Project Title: Water Lane, Angmering

Project No/ Document Reference: A290-TN007

DRAINAGE – CONDITIONS DISCHARGE

© ABLEY LETCHFORD PARTNERSHIP LTD.
This drawing should not be reproduced without consent.

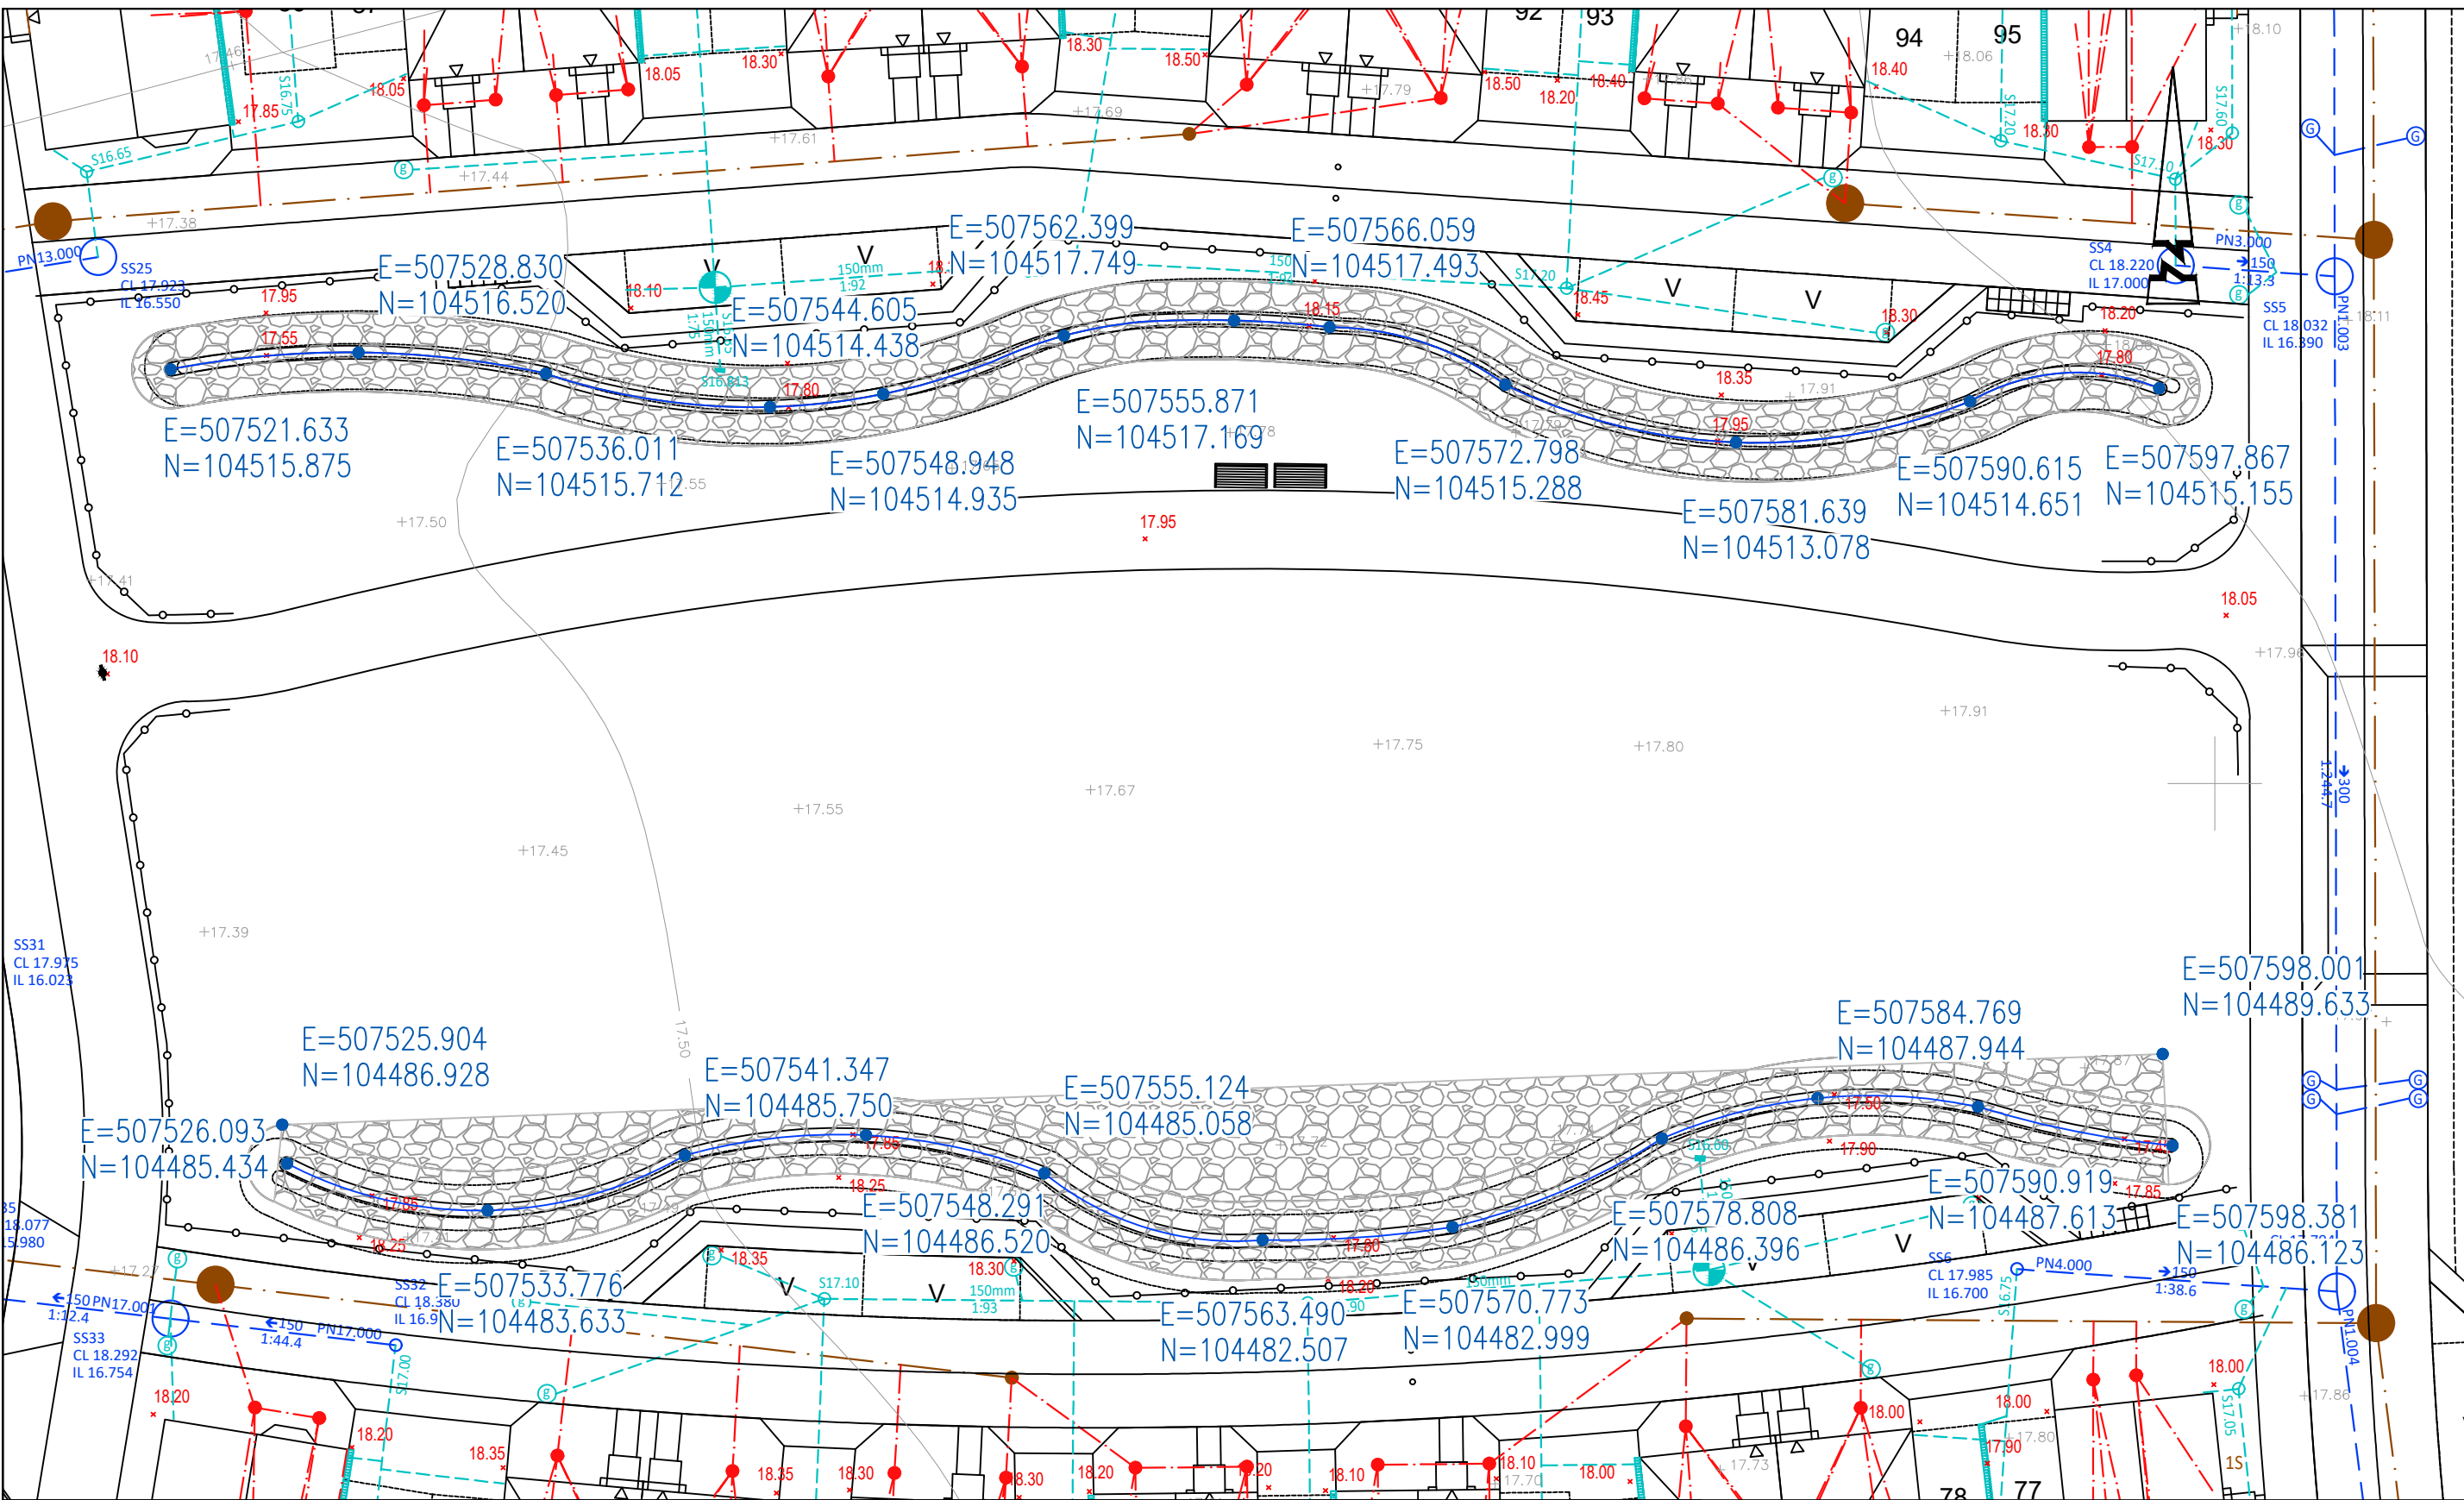
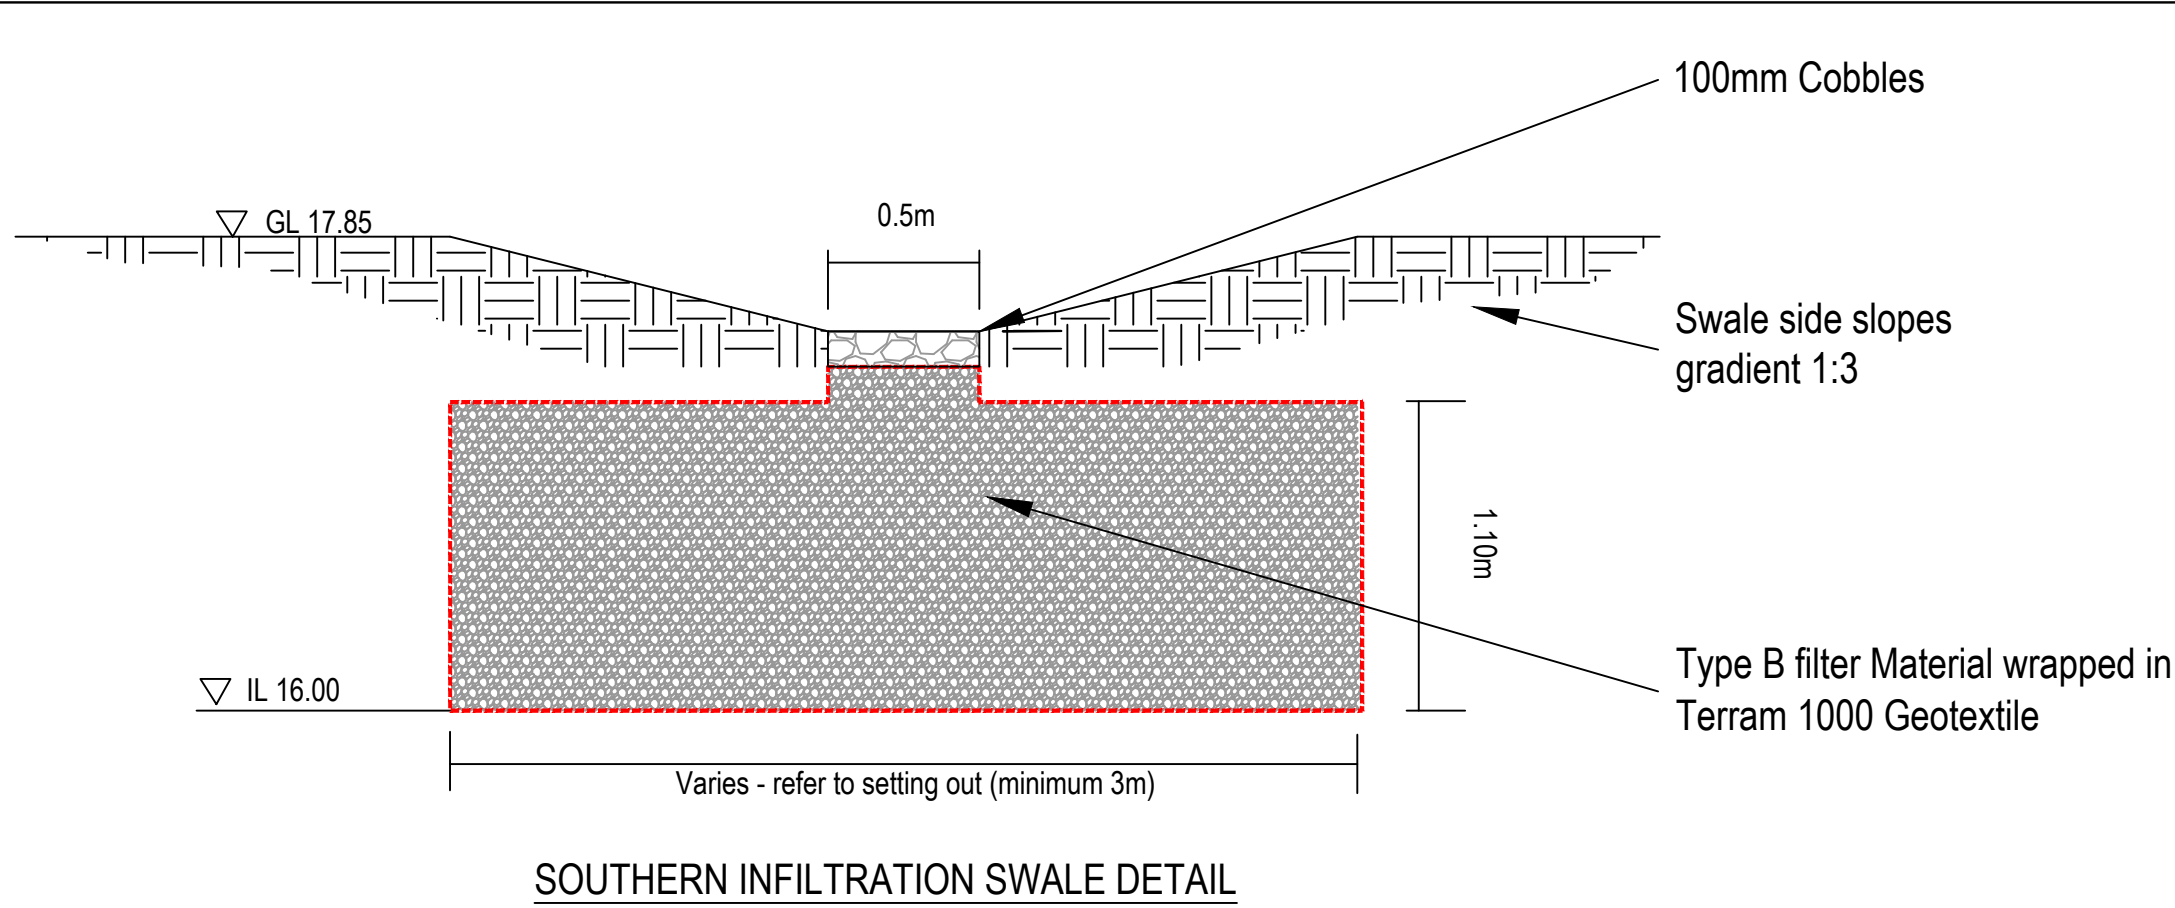
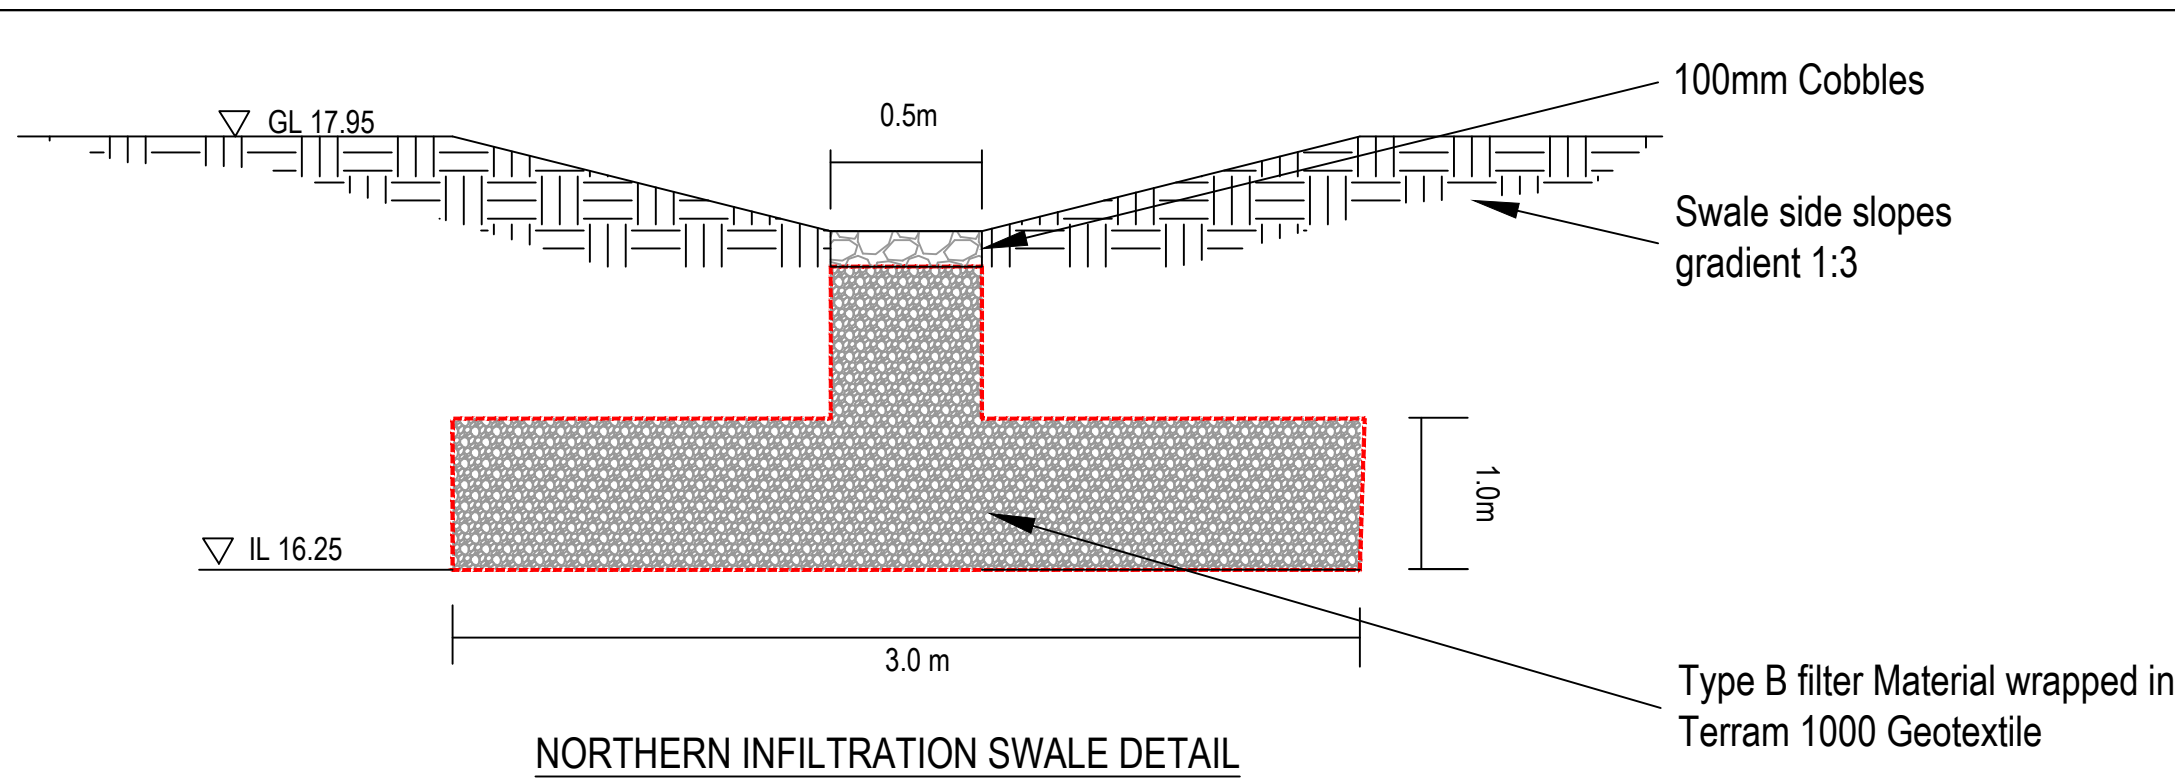
1. *Calculation printouts do not include pipeline schedule printouts of upstream and downstream manholes. This combined with layouts not showing pipe numbers makes it very time consuming to review. I therefore have not reviewed the calculations. Please supply further calculation printouts and include pipe numbers on plan. Please see comments below (24 onwards)*

15. *Please detail swale invert levels, top of bank levels, side slopes, and any bed slope on drainage layout plans.*

19. *Please detail incoming pipe invert levels on the central swales. Please include invert level of swale on plan*

All calculations are provided again and amended as per your comments. All pipe numbers have been included on all plans.

This has been noted and included on the drawings.

This has been noted and included on the drawings, as previously.
